DRB CASE ACTION LOG (PREL & FINAL PLAT)

DRB Application No.: 06DRB-01290 (P&F)

Project # 1003010

Project Name: LANDS OF ABQ LITTLE THEATRE

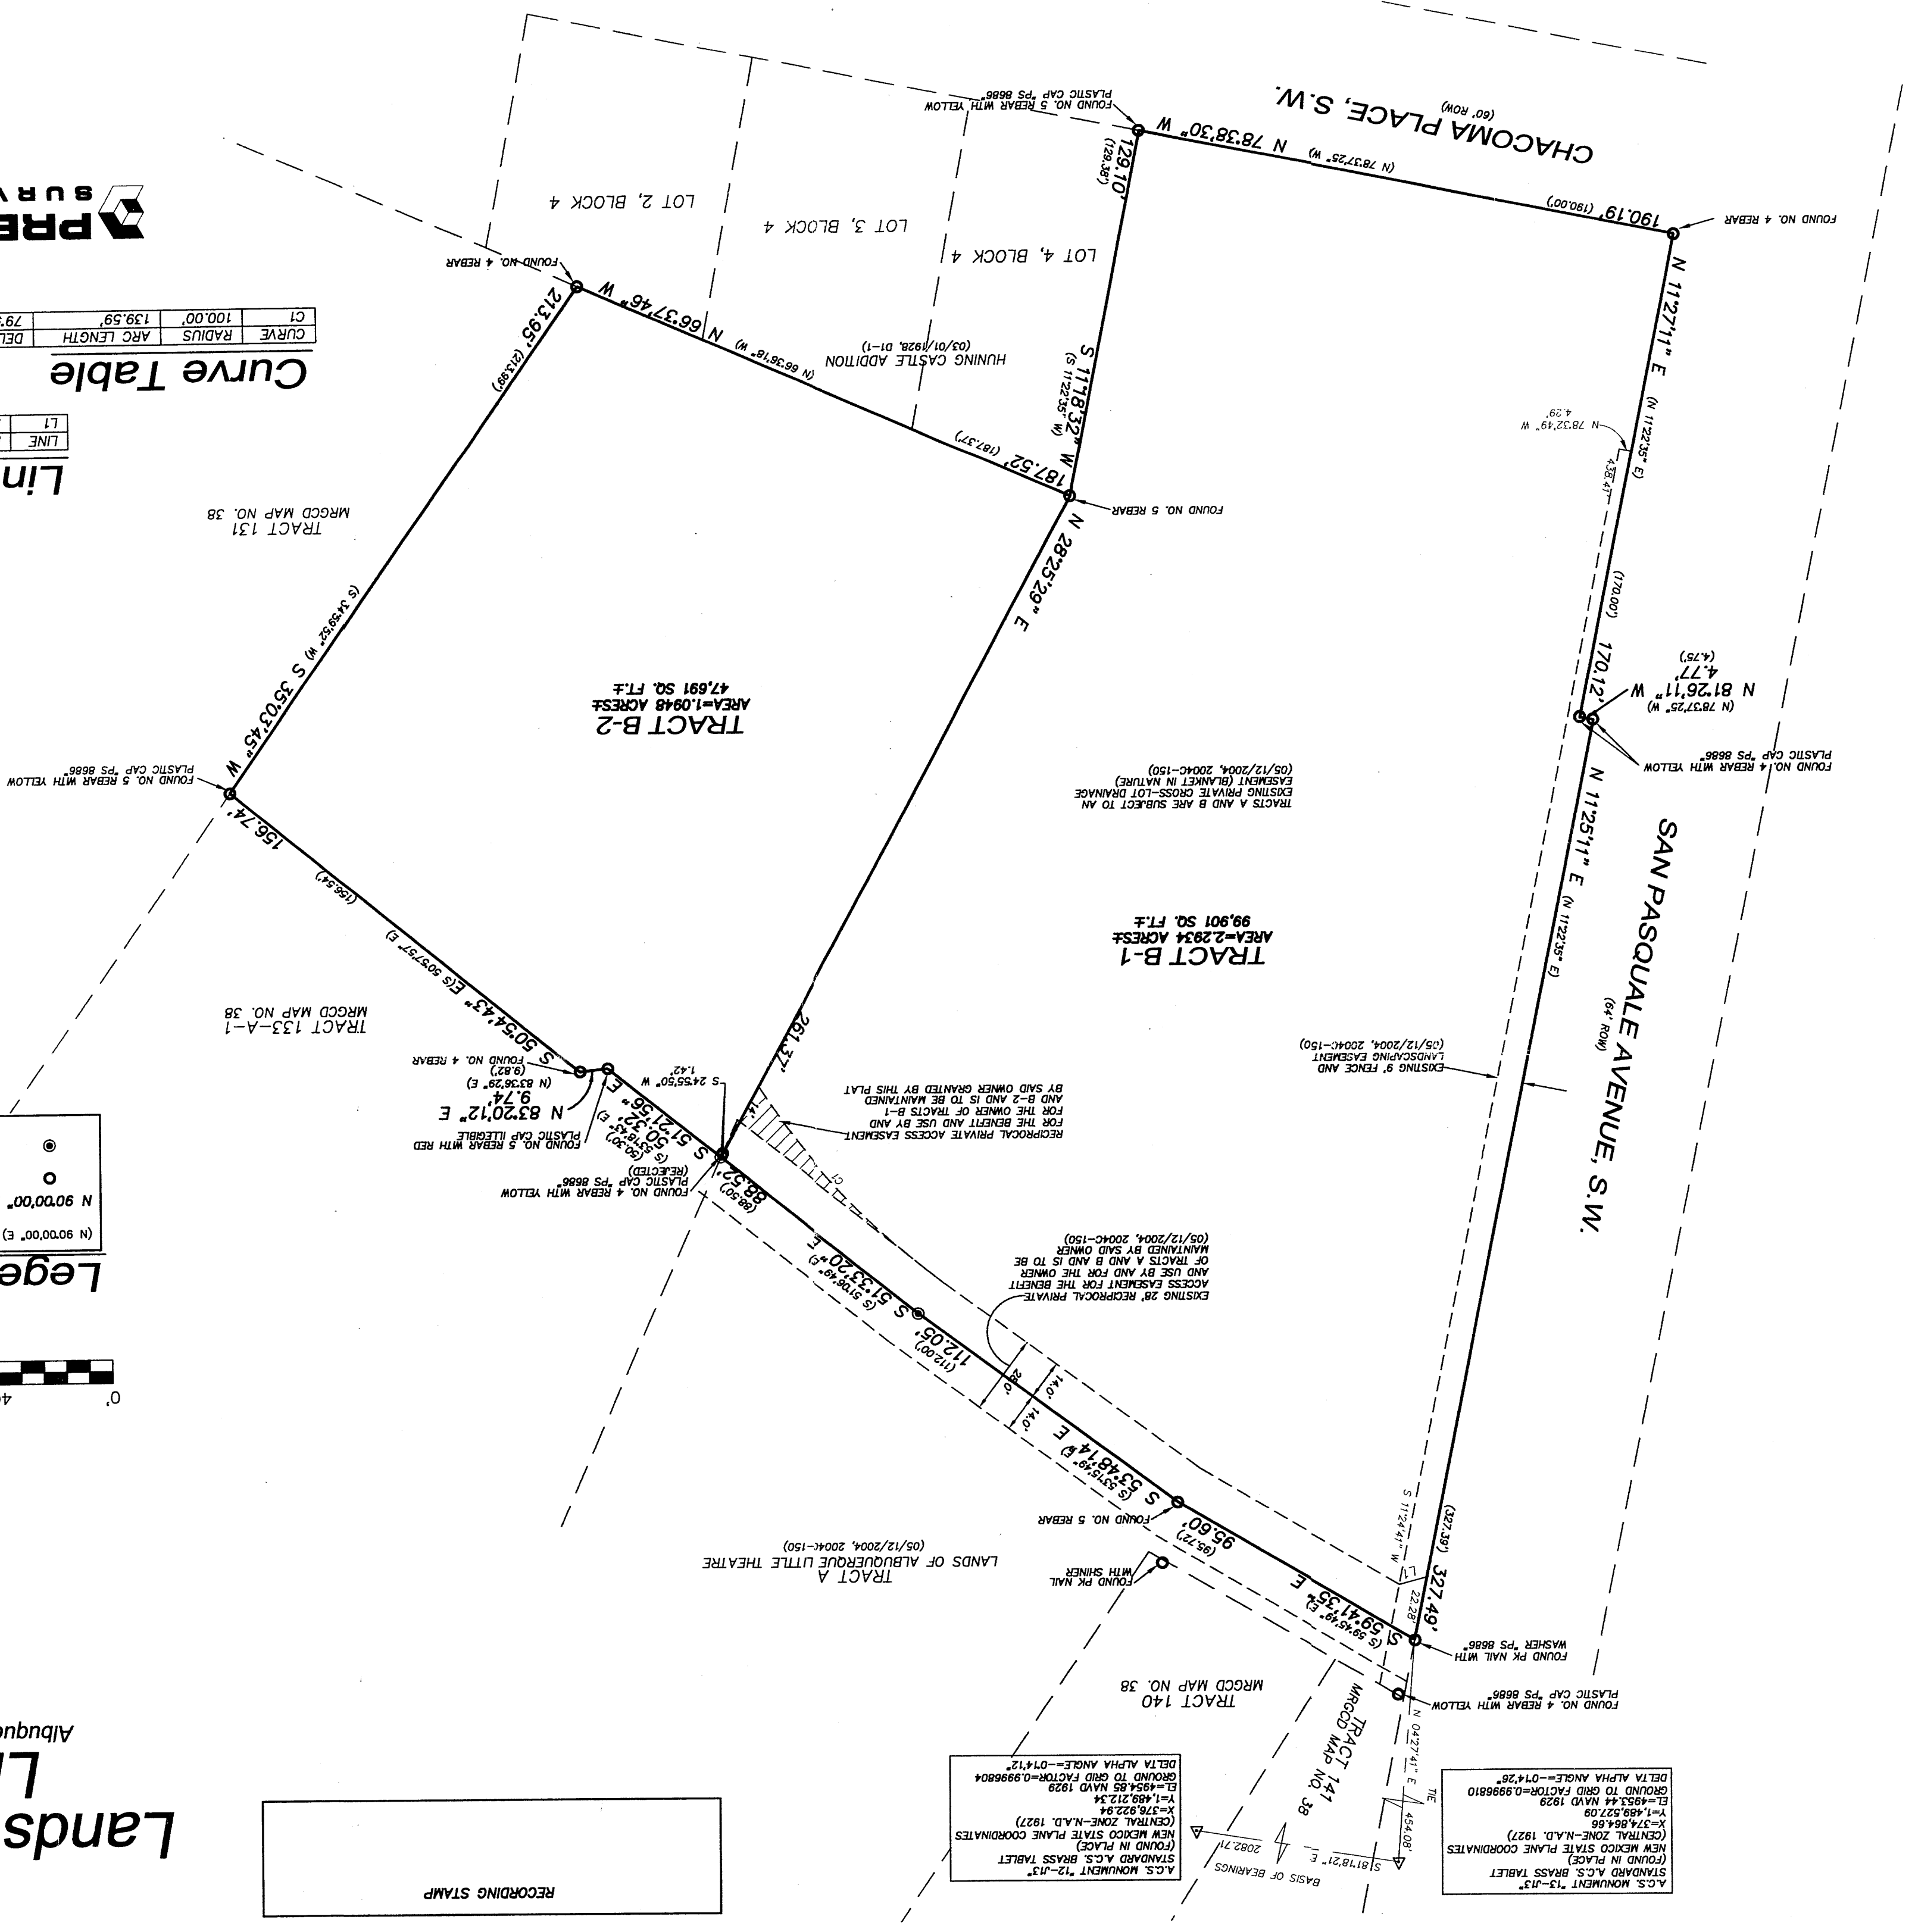
- TRANSPORTATION: * REQ'D PARKING / sk
- * S.WATER DEDICATION / EASEMENT / sk
-
-
-

- UTILITIES: On North edge of Tract B-1, on the proposed 28' private access easement, Add language for a public water and sewer easement.
-
-
